From: Rachel . <blparishclerk@outlook.com>
Sent: 24 August 2022 19:40
To: Planning
Subject: 3/2022/0400

Following the meeting of the parish council held on the 22nd August 2022, discussion took place regarding the planning application 3/2022/0400 for which there has been a discharge of conditions.

Title
**PROPOSED PRIVATE
DRAINAGE LAYOUT**

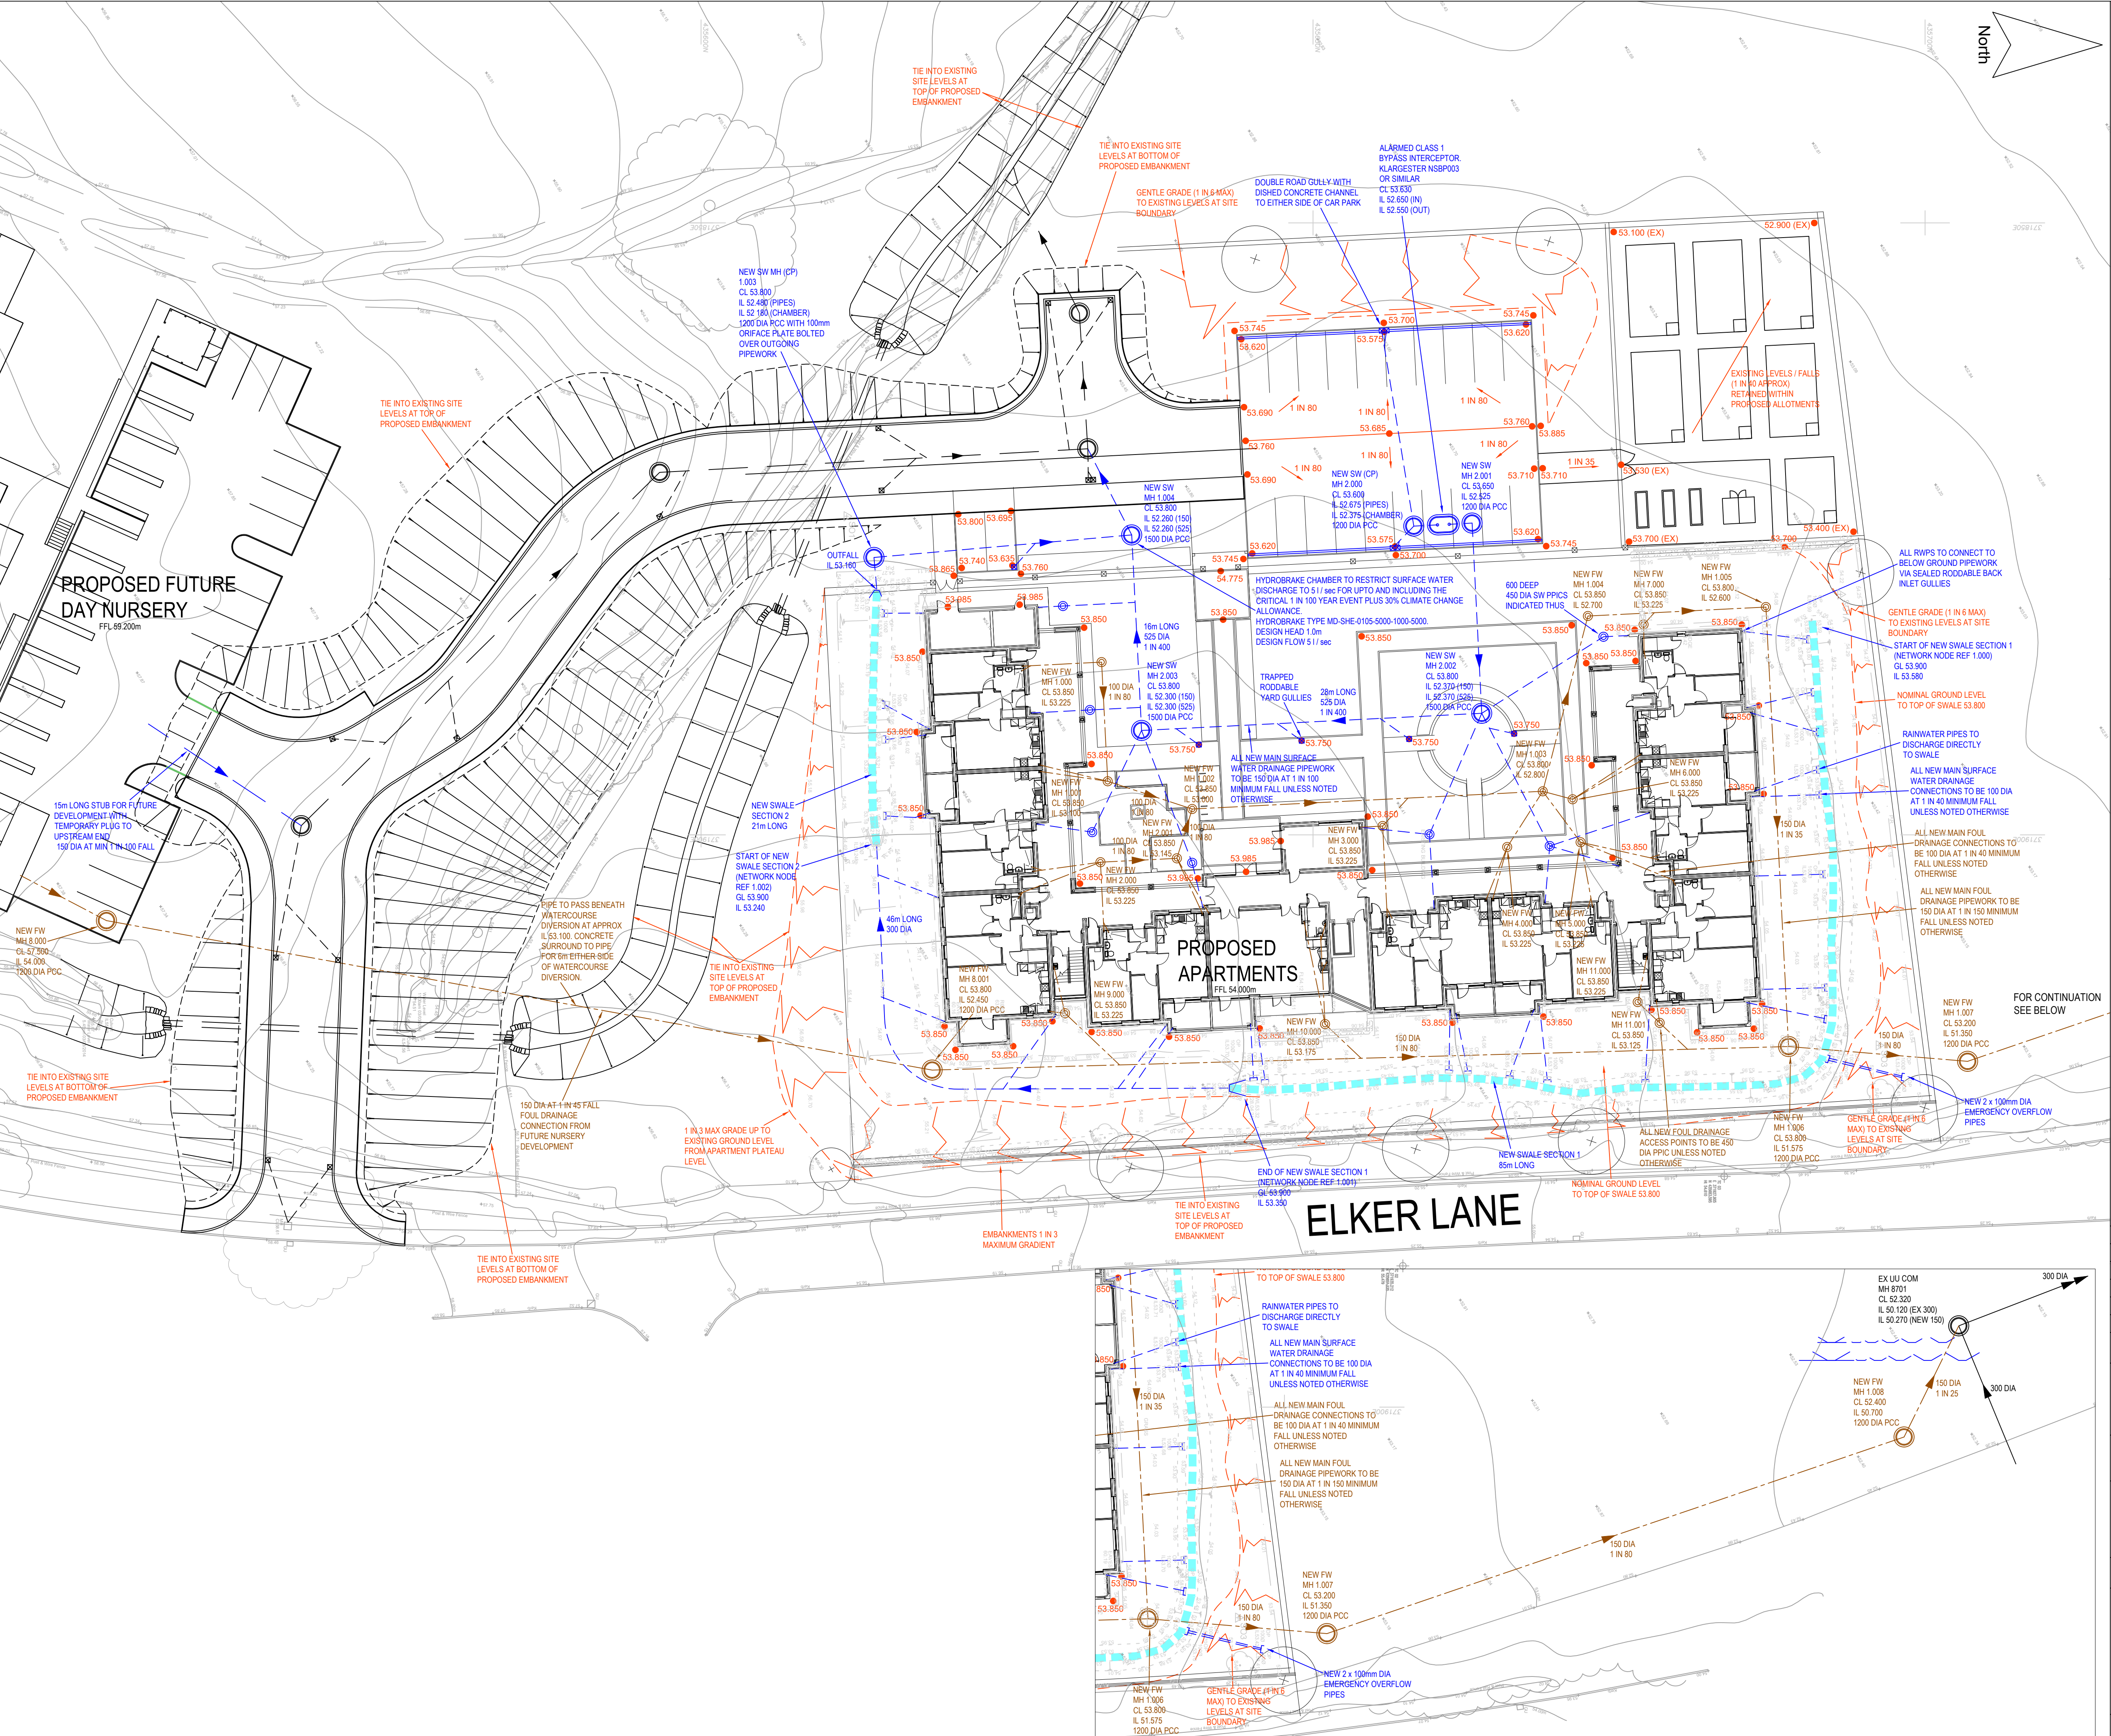
1. The swale being an open ditch with standing water, the smell and pests therein.
2. The flooding that has happened 3 times in the past 4 years reeking misery for the residents.
3. The vermin on site from the swale

This discharge of conditions will not prevent the existing problems and the parish council wish to express their disappointment at the disregard for the evidence put before them.

Could the parish council ask that a rationale is provided for why the conditions have been discharged particularly with reference to the swale, flooding and vermin.
